Engineers Comments Regarding Surface Water Drainage

APPLICATION NO: FG/141/19/PL

Site Address: Elm Lodge Tamarisk Way Ferring BN12 5ER

Description of Works: Erection of 1 No detached chalet style dwelling with integral garage; demolition of existing conservatory & porches & erection of single storey side extension & part single/part two storey side extension to Elm Lodge (resubmission of FG/220/18/PL).

PROPOSED SITE PLAN

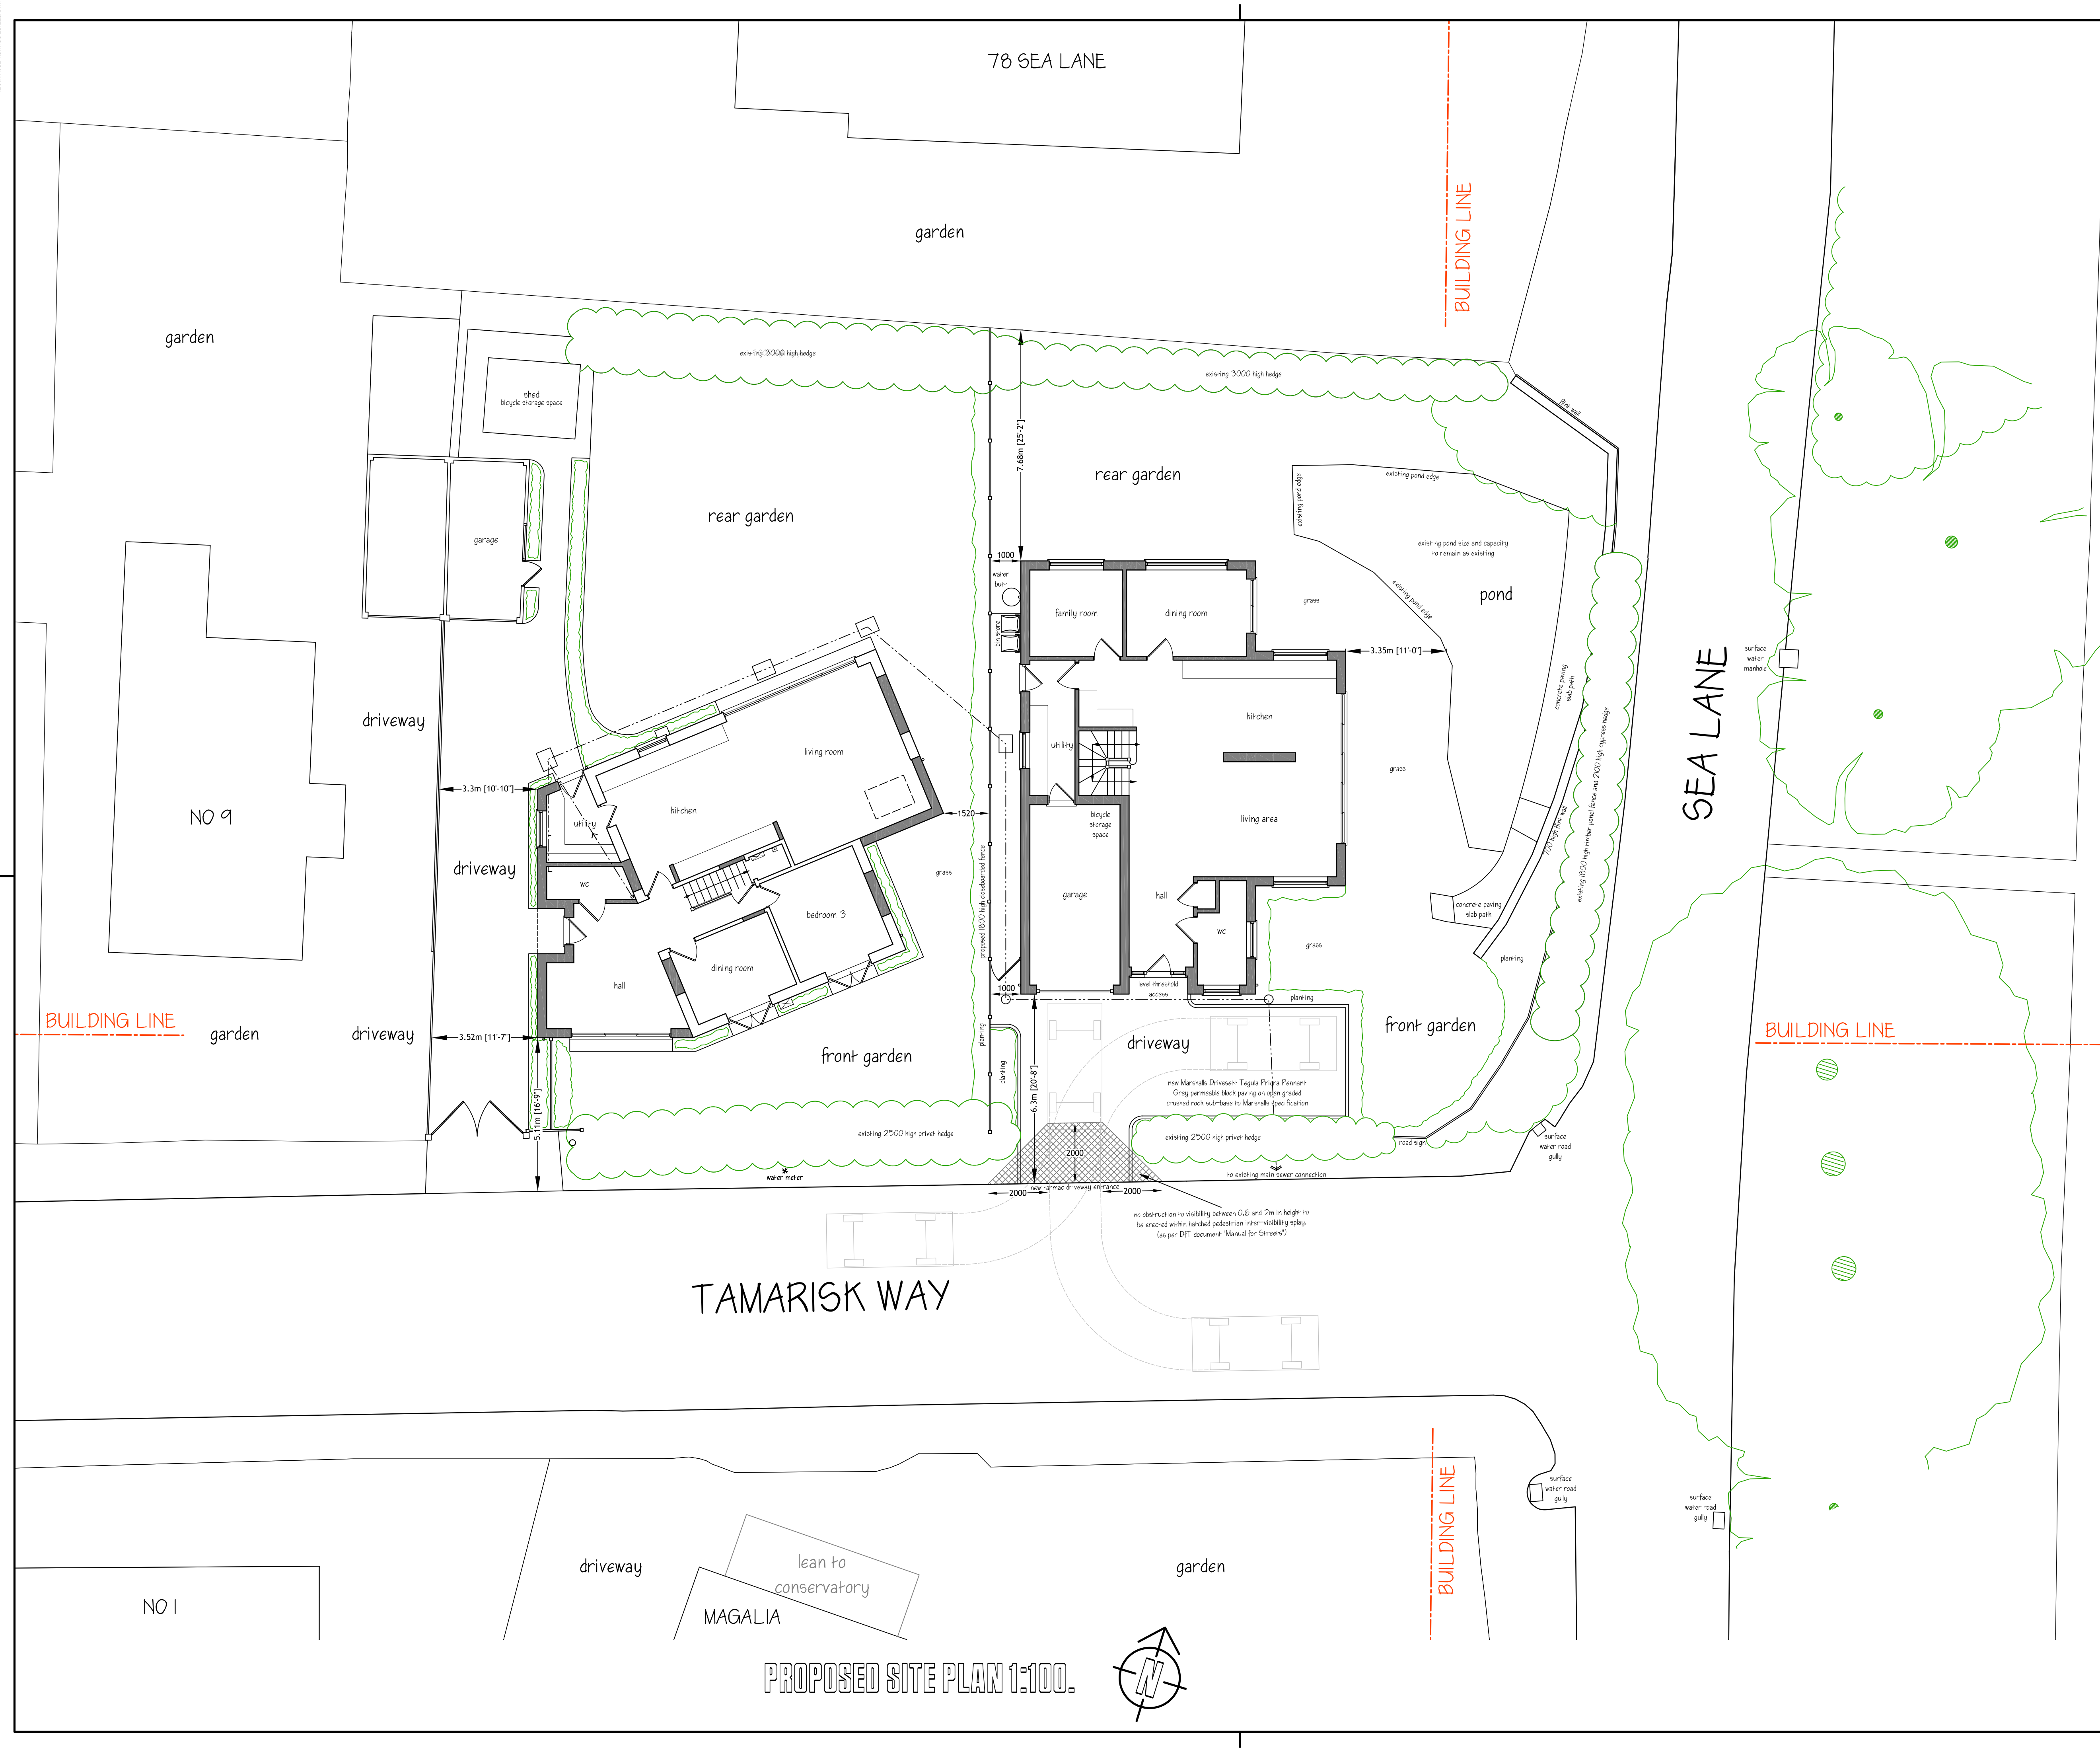
On the basis of the known surface water drainage network in the vicinity of the proposed development, there are concerns that there may be an unmapped pipe leading to the pond, located under the garden to the north of the proposed building. It is not permitted to restrict current and future land owners from undertaking their riparian maintenance responsibilities in respect to any watercourse or culvert on or adjacent to the site as a result of construction activities. The local byelaws require a 3m easement from any watercourse be it open or piped.

If you are minded to approve the application please apply the following conditions to ensure that the development is adequately drained and does not increase flood risk elsewhere. If these conditions are applied, the applicant is encouraged to liaise with the engineering department to organise conducting intrusive investigations into the location of the suspected culvert in order to discharge condition PCENG3.

PCENG2

“Development shall not commence, other than works of site survey and investigation, until full details of the proposed surface water drainage scheme have been submitted to and approved in writing by the Local Planning Authority. The design should follow the hierarchy of preference for different types of surface water drainage disposal systems as set out in Approved Document H of the Building Regulations, and the recommendations of the SuDS Manual produced by CIRIA. Winter groundwater monitoring to establish highest annual ground water levels and winter Percolation testing to BRE 365, or similar approved, will be required to support the design of any Infiltration drainage. No building / No part of the extended building shall be occupied until the complete surface water drainage system serving the property has been implemented in accordance with the agreed details and the details so agreed shall be maintained in good working order in perpetuity.”

PCENG3

“The development shall not proceed until details have been submitted to and approved in writing by the Local Planning Authority for any proposals: to discharge flows to watercourses; or for the culverting, diversion, infilling or obstruction of any watercourse on or adjacent to the site. Any discharge to a watercourse must be at a rate no greater than the pre-development run-off values. No construction is permitted, which will restrict current and future land owners from undertaking their riparian maintenance responsibilities in respect to any watercourse or culvert on or adjacent to the site. “
